**Re Planning Application No.EP/93/15/HH
Statement lodged 13/08/2015**

Errors and omissions in Mr Rollason's Statement

ERRORS AND OMISSIONS ON PLANS SUBMITTED FOR PLANNING APPLICATION: 14 WORTHING ROAD

PROPOSED ROOF PLAN 1:100

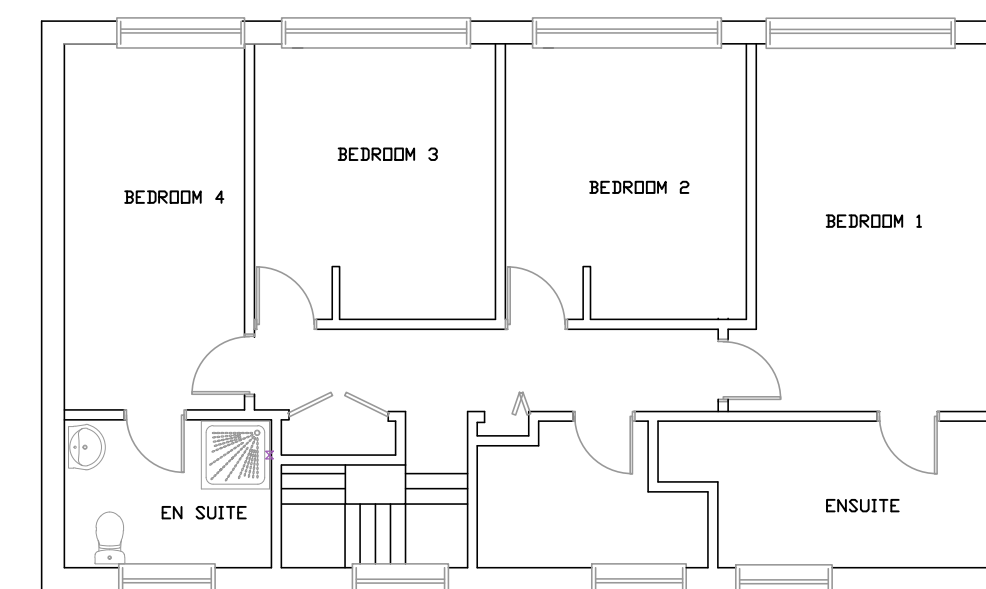
22. **Page 5** the 3.5 mtrs extension is on the western edge of his property. The new sitting room is included in the 7.5 mtrs extension along eastern boundary. The **Proposed Roof Line Plan** drawing has been inverted to show length along his Western Boundary

REAR ELEVATION
South

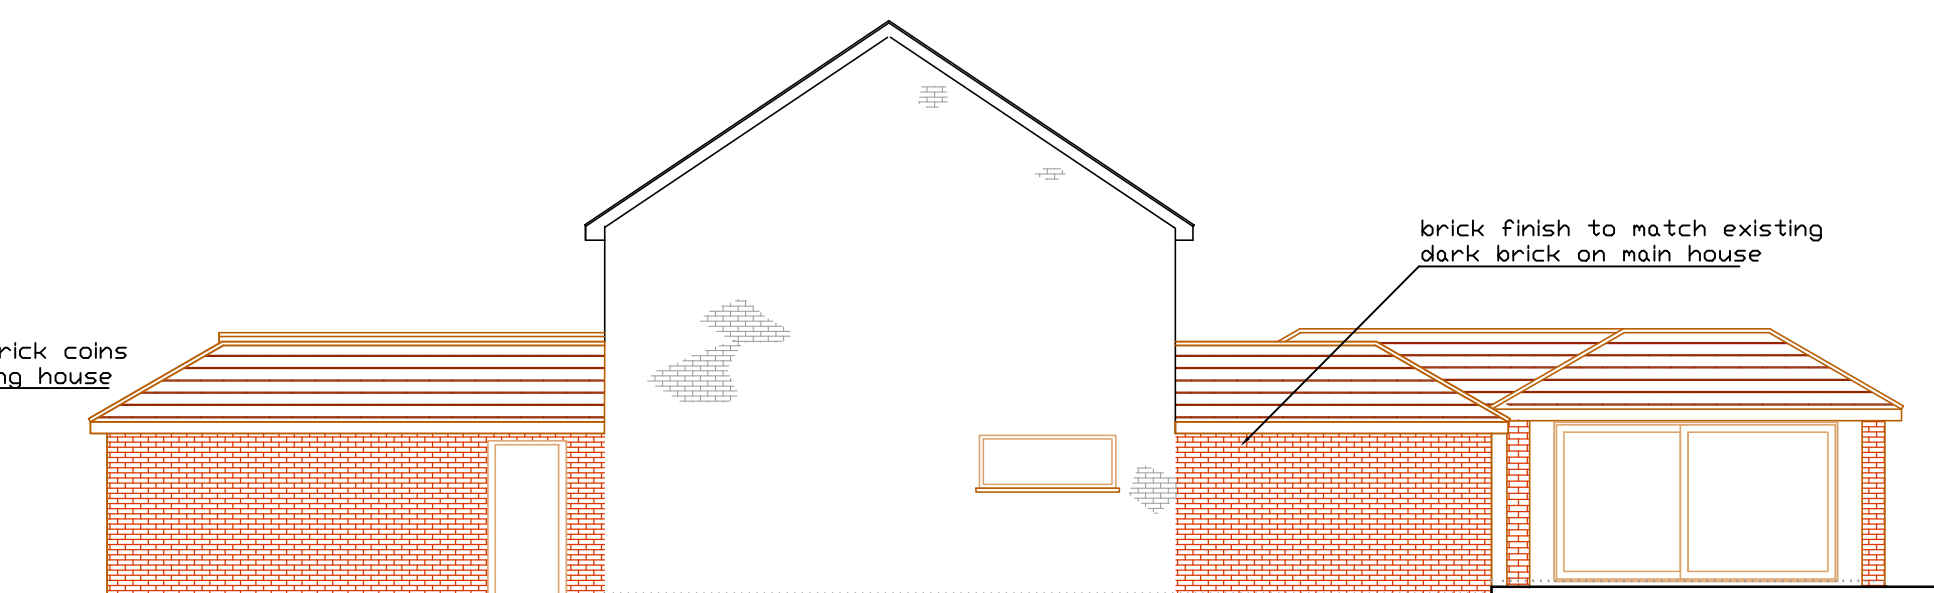
8. **Page 2 para 5.** The rear south elevation is now to be "piecemeal" with differing roof heights, different roof styles and differing depths.
This will affect the view from Langmeads field, owned by Arun District Council.

11. **Page 3 para 2** the new South Rear Elevation Plan shows the roof height to be above the window sill along the Eastern boundary of the rear extension.

EXISTING FLOOR PLANS 1:50

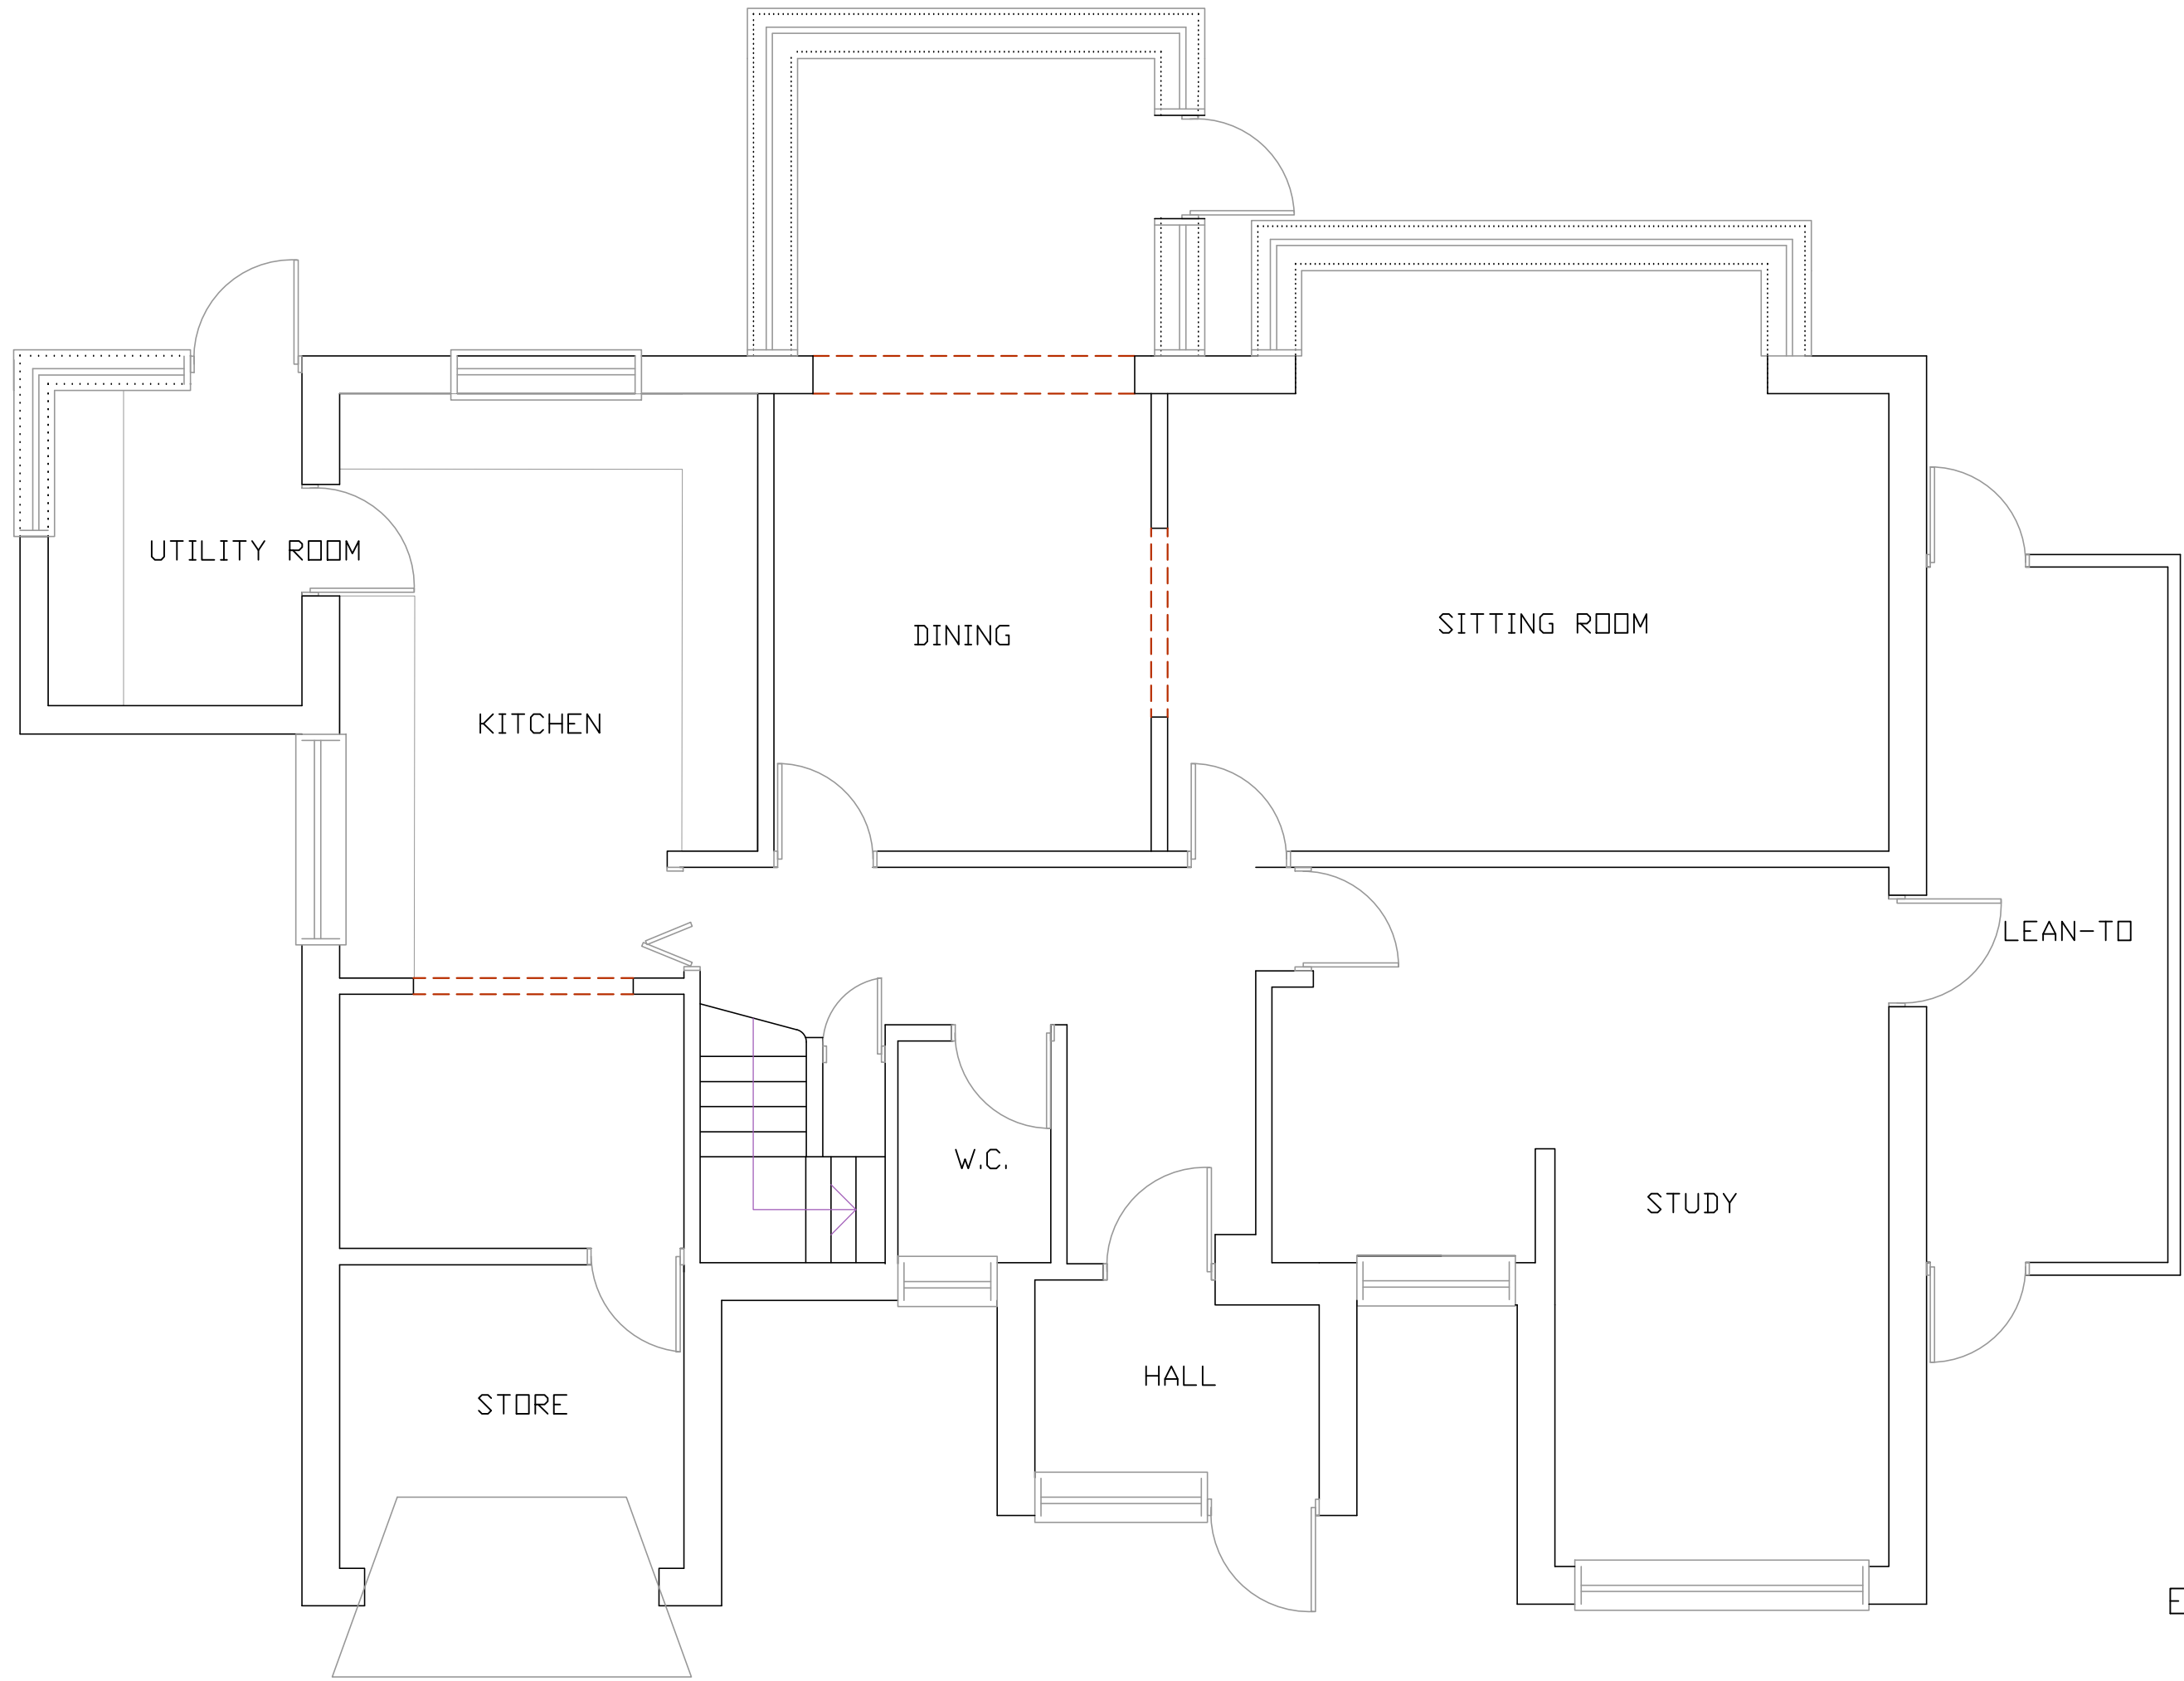
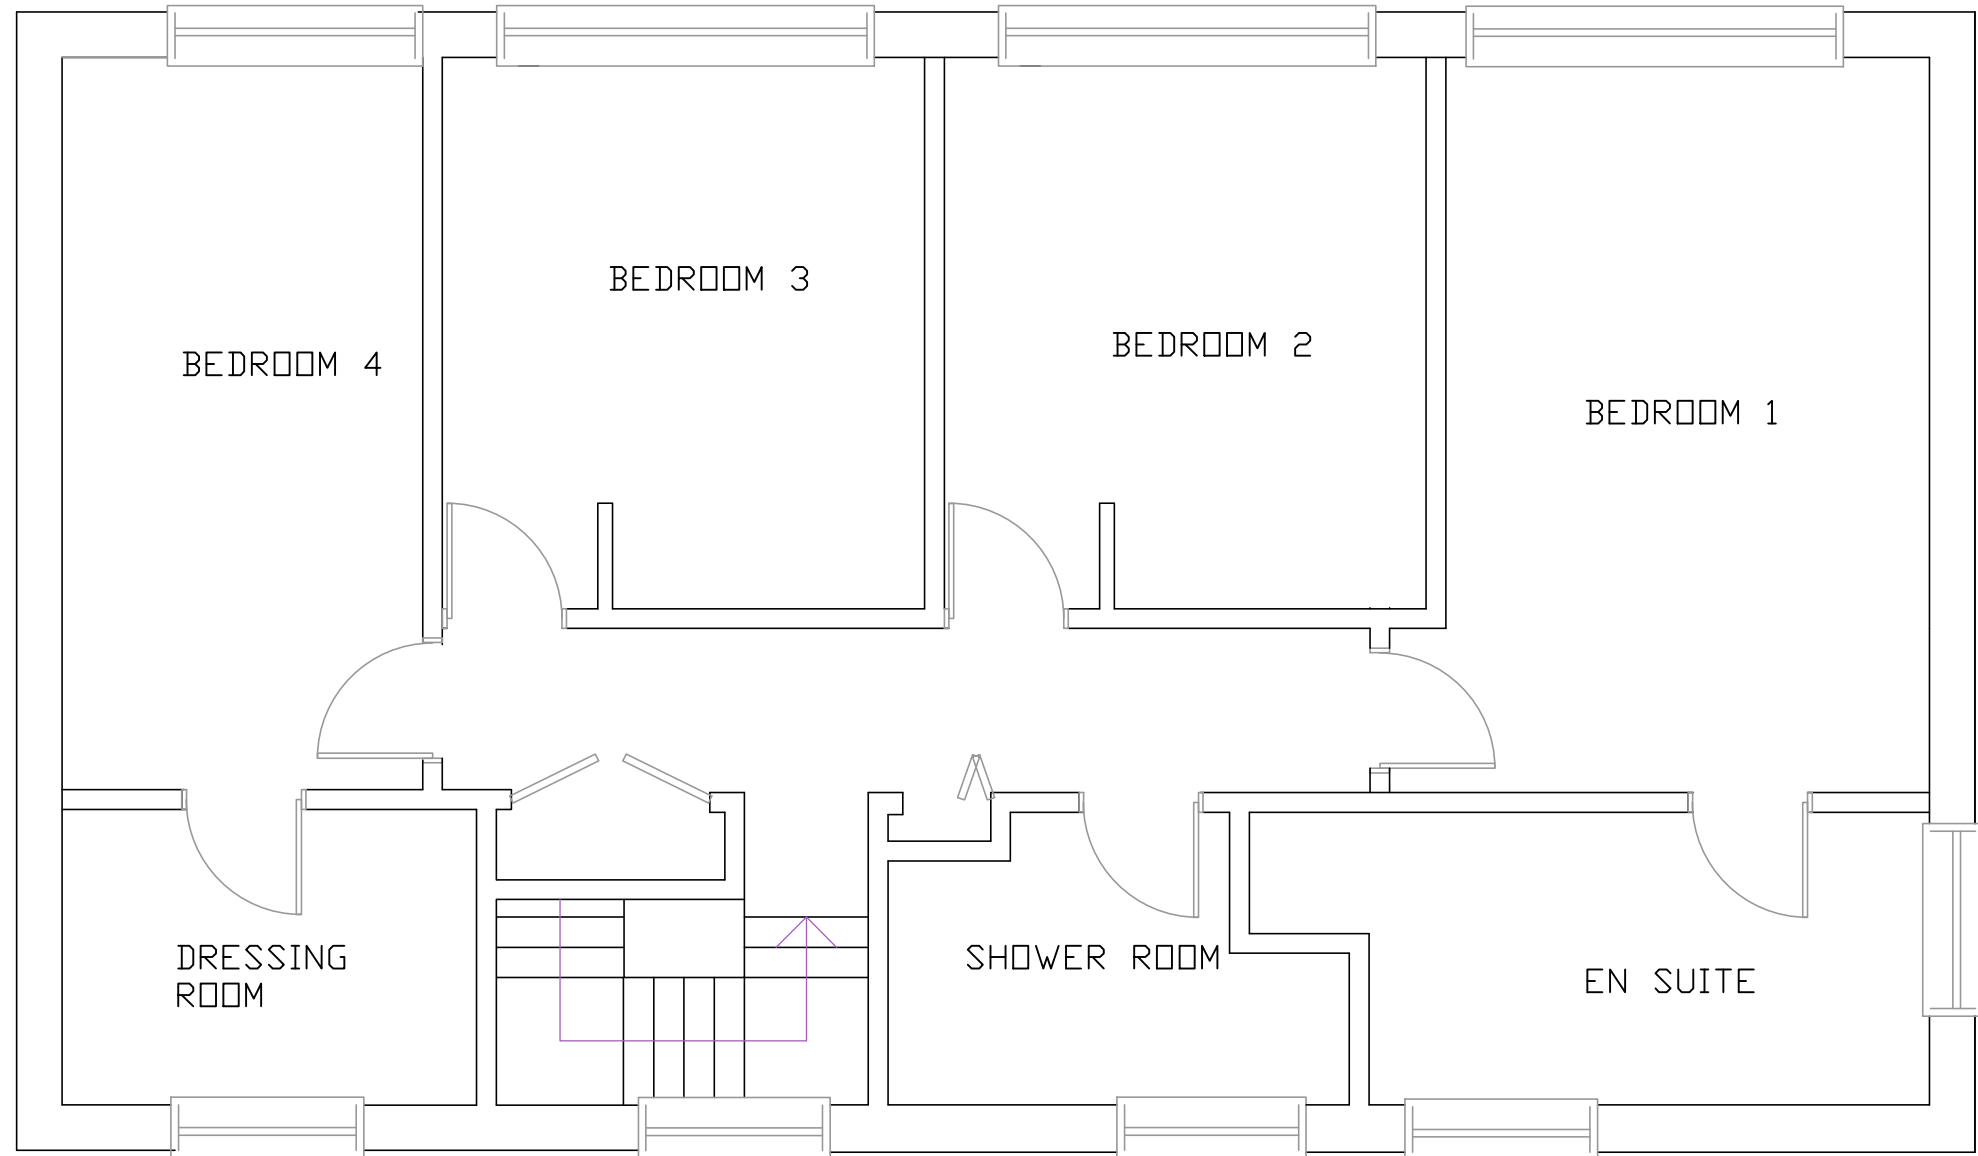
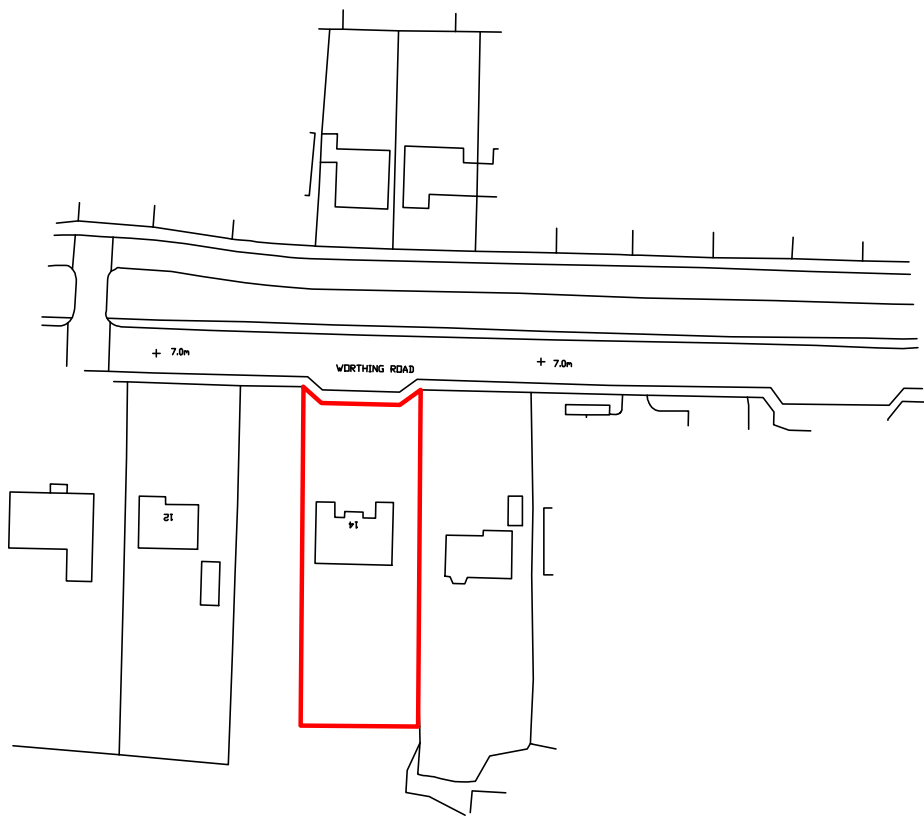
9. **Page 2 para 5** No 16 is the original property, built 1927.
10. **Page 3 para 2** The Prefabricated garage is not shown on the submitted Existing Ground Floor Plan, nor on the Eastern side elevation of the Existing Ground Floor Plan

ITEM	ERROR	COMMENT	REFERENCE IN MR ROLLASON'S SUPPORTING STATEMENT 13/08/2015
Existing Floor Plans	Single garage at Eastern Boundary not shown.		P3 para 2
PROPOSED PLANS	Proposed Roof Plan inverted	Shows length along No 14 Western Boundary, rather than Eastern	
	Covered Walkway omitted	A room with power points, lighting and lockable doors north and south. Extends from House wall to Western Boundary wall	P6 2.07
	Window & Door in East Elevation	"no windows are to be provided in this elevation"	P5 para 2
	Eastern Boundary Wall Block Plan	The Plans do not show the narrowing of Mr Rollason's plot, Boundary wall indented 90cm	P2 para 5, P4 para 8
